Objection To Planning Application - 2024/62/91242/E

Title:  
**5km Cycling Catchment Plan  
 Shepley Road, Stocks Moor**

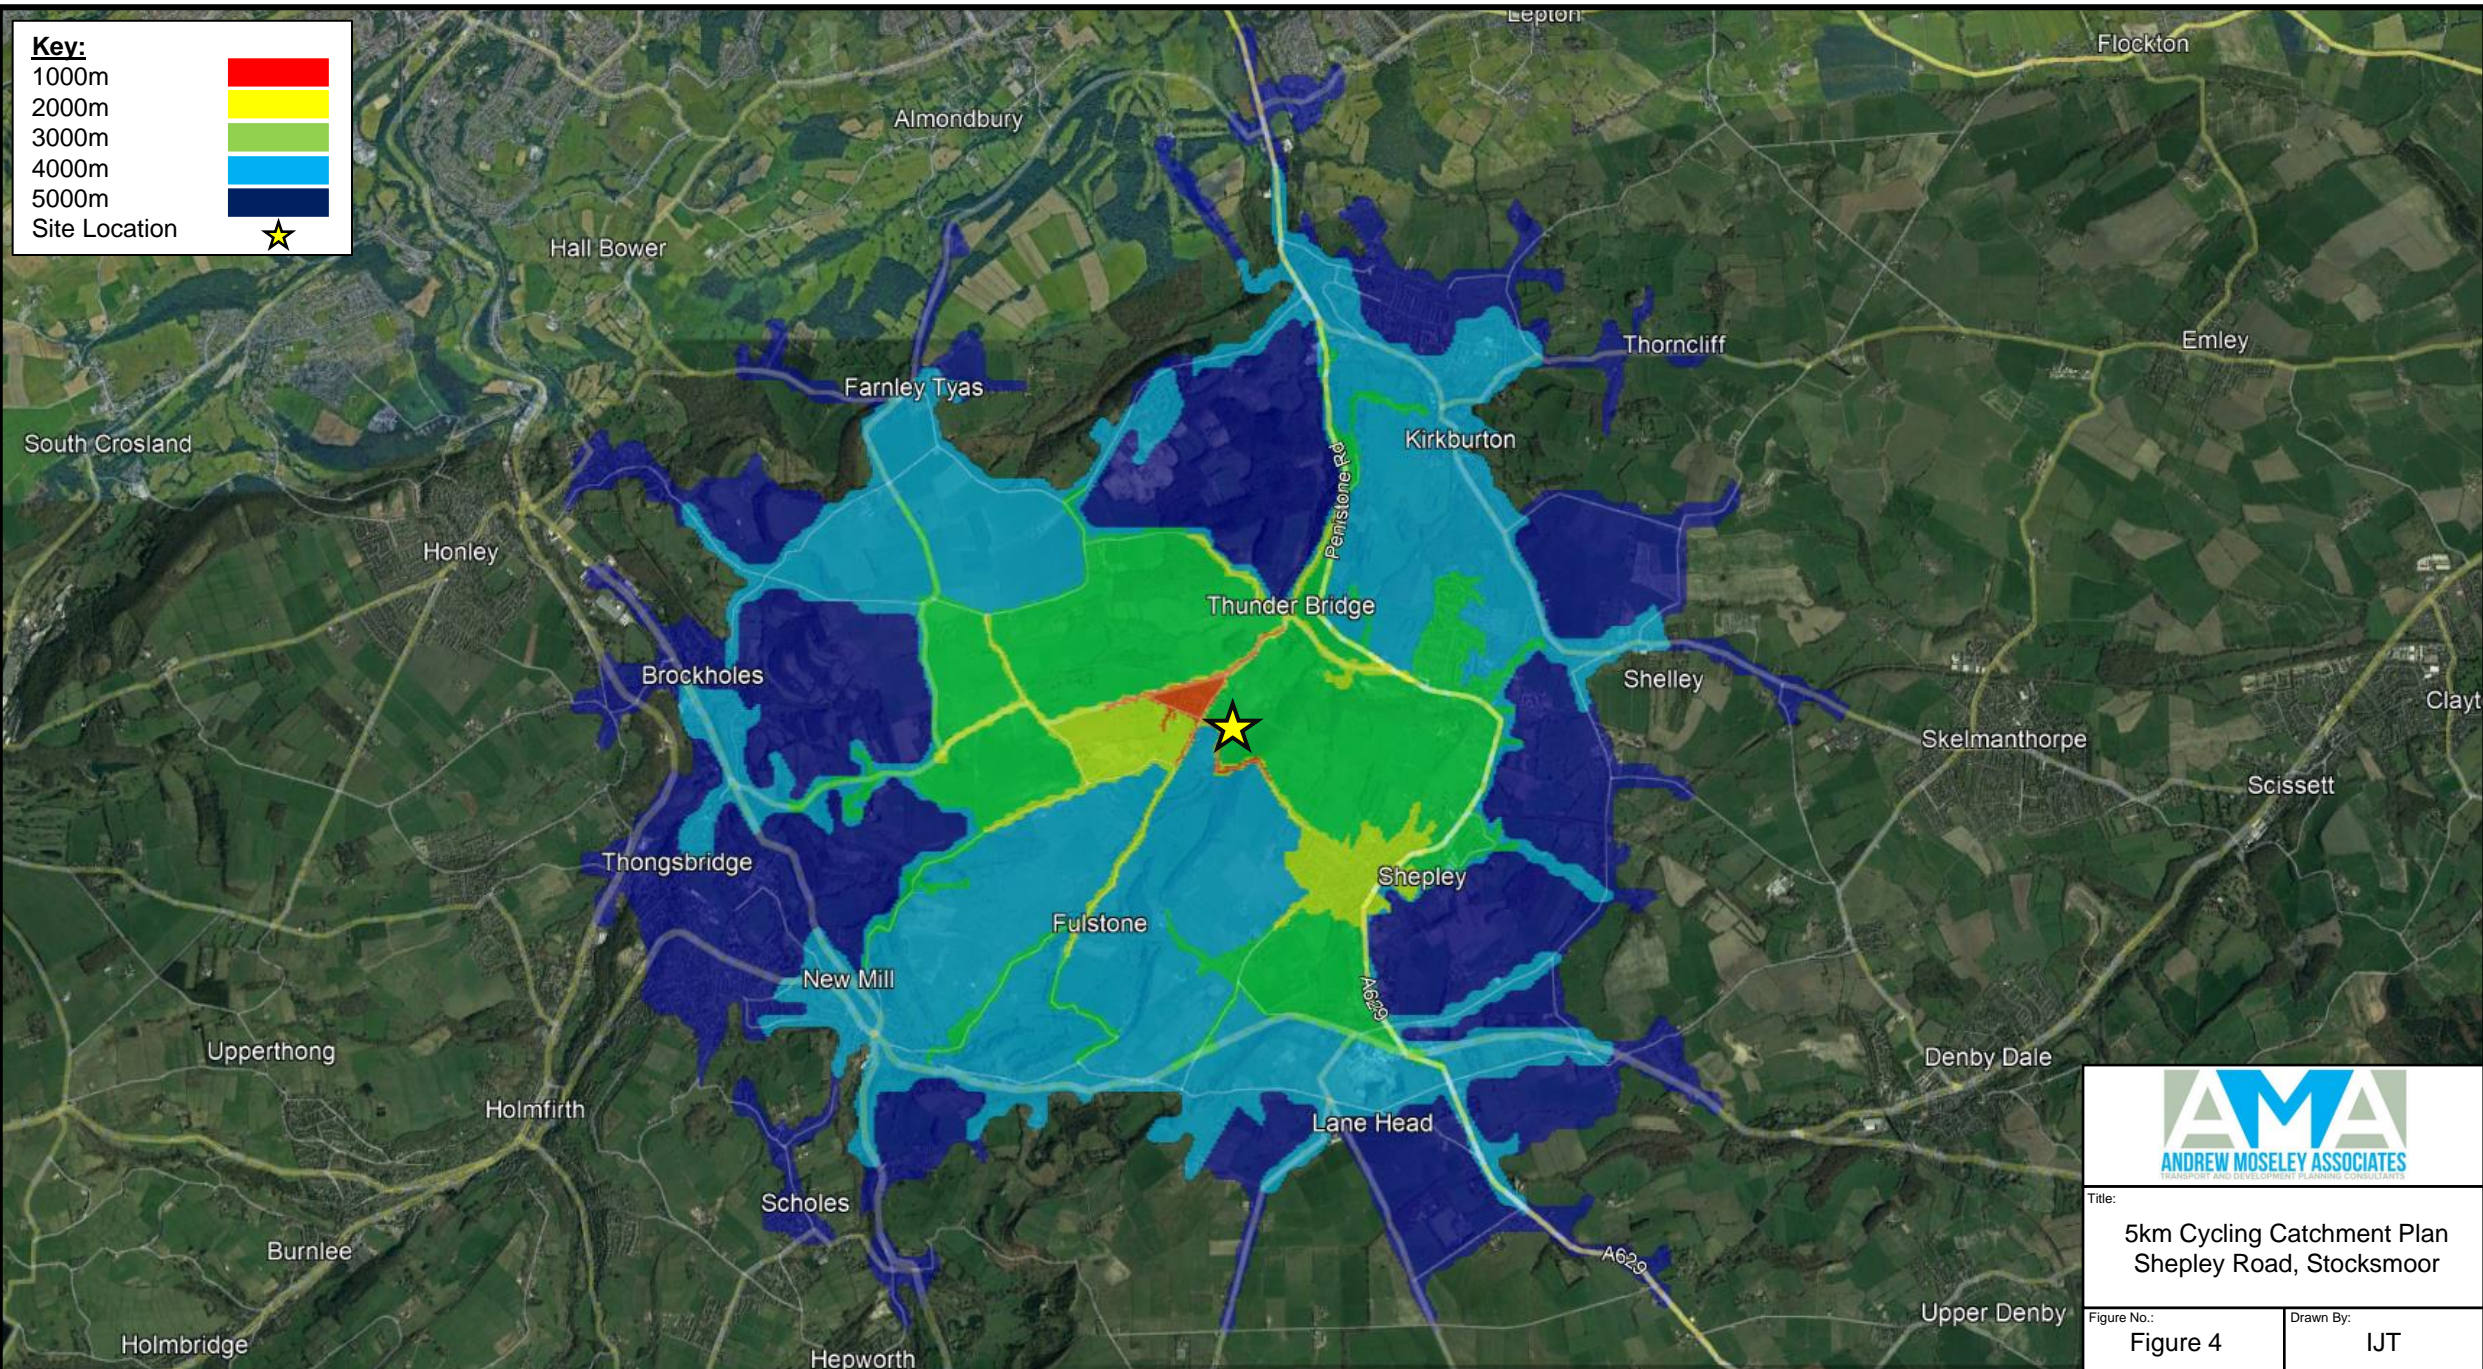
If people are looking to commute by bike to work and assuming this is Huddersfield. This would be highly unlikely as the main routes into Huddersfield are dangerous and busy main roadways with limited and broken cycle paths. The distances to the main centre of Huddersfield are around 8 miles (one way and 16 miles round trip) from Stocksmoor. Would you commute for 16 miles every day on a bike to get to work? People would choose to drive adding to the congestion and points mentioned above and therefore does not apply to sustainability criteria.

The AMA Traffic Report states “Guidance suggests that the preferred maximum cycle distance in which people are willing to cycle is 5.0km.” It is therefore unlikely that people will sustainably travel (via bike) into Huddersfield the main economic area.

Stocksmoor has lots of hills. Have the plans considered E-bike access at the development as most people (if not trained cyclists will struggle with the steep hills that allow access into and out of the community of Stocksmoor.

<b>27/03/2024</b> <b>AMA/20547</b> <b>Figure 7</b>	<b>Shepley Road, Stocksmoor</b>	- Drawn by: SD Checked: AMM	<b>AM</b> <b>08:00 - 09:00</b>
	<b>Proposed Trip Distribution (%)</b>		<b>PM</b> <b>17:00 - 18:00</b>
			<b>SAT</b> <b>N/A</b>

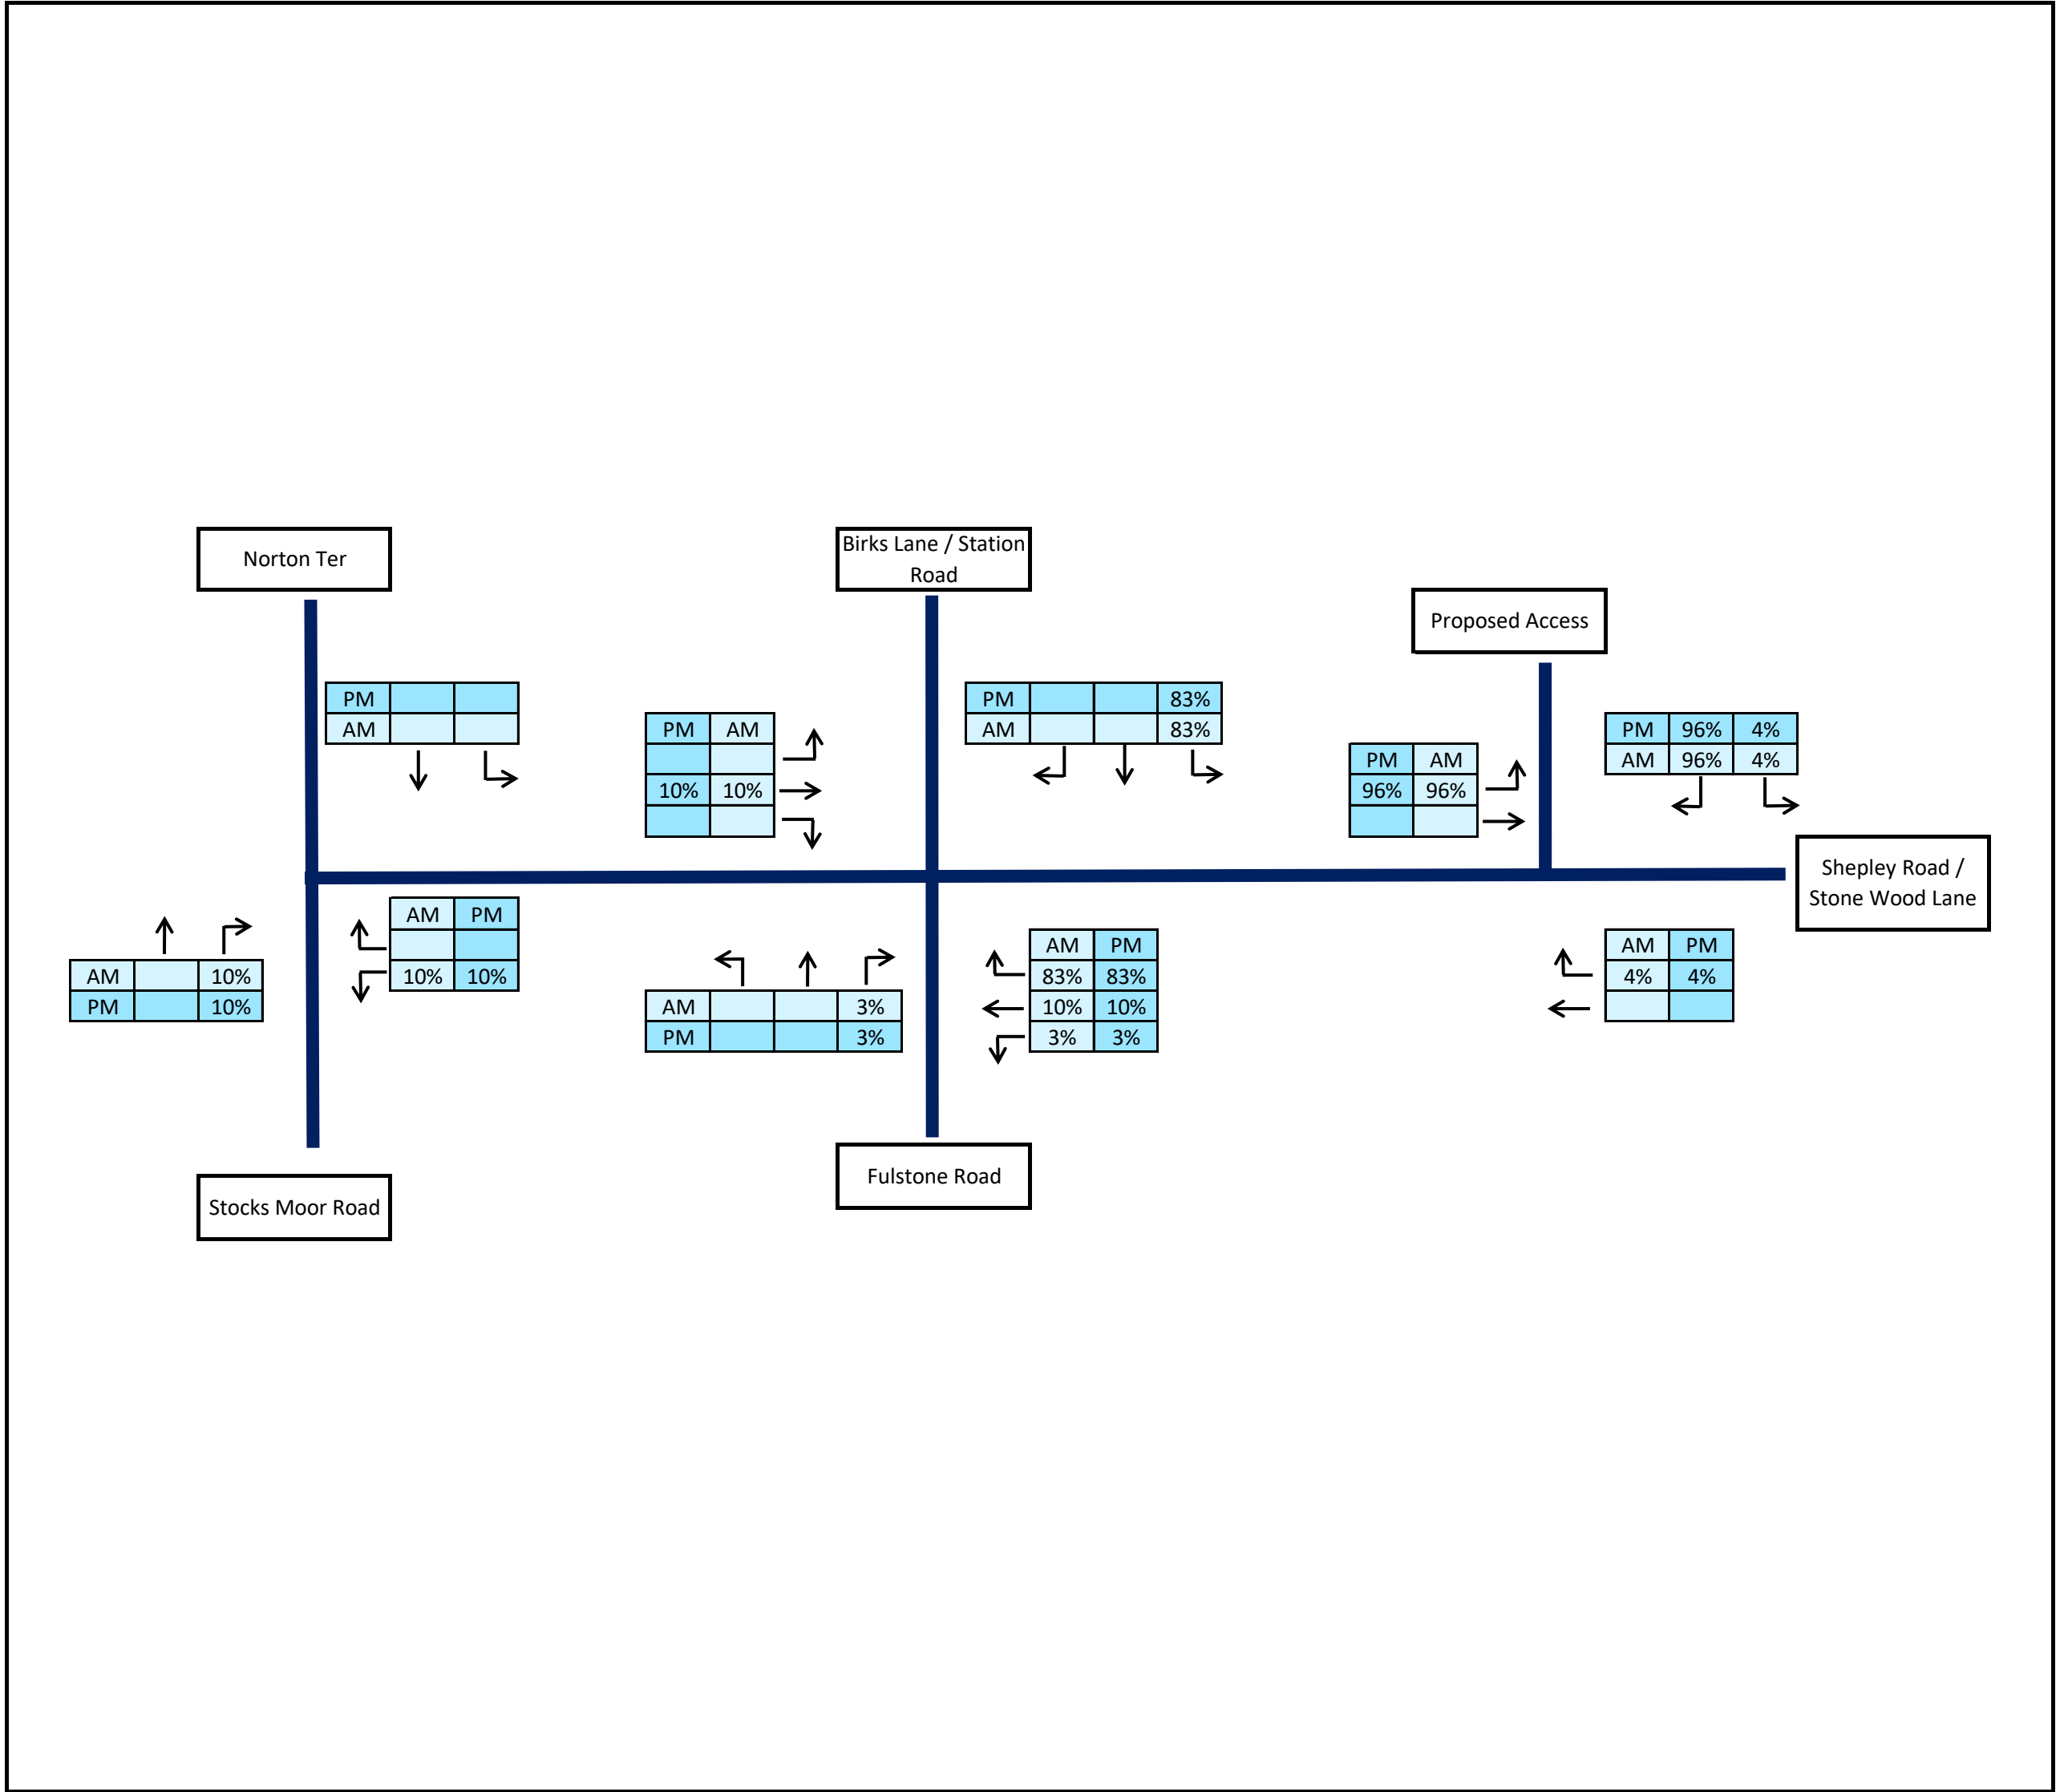
Route Choice	Trip Distribution (%)
Shepley Road / Stone Wood Lane	3.8%
Fulstone Road	3.1%
Birks Lane / Station Road	82.6%
Stocksmoor Road	10.5%

I believe this figure to be miscalculated and doesn't factor the specifics of the village but instead uses national data and averages to make an assumption.

5.3.3 of the AMA Traffic Report suggests It is stated that only 3.8% of traffic would traverse through Shepley Road and via Stone Wood.

I believe this to be a miscalculation as this only factors in commuting and working but doesn't factor in the need to travel via Stone Wood Lane to get to the nearest amenities such as Shepley Doctors Surgery, Pharmacy, Food and Convenience stores of Shepley Coop and Sovereign Petrol Station and also Shepley Dental service on Marsh Lane. All of which are some of the closest amenities to Stocksmoor residents. There are two popular pubs in Shepley such as the Farmers Boy and the Black Bull.
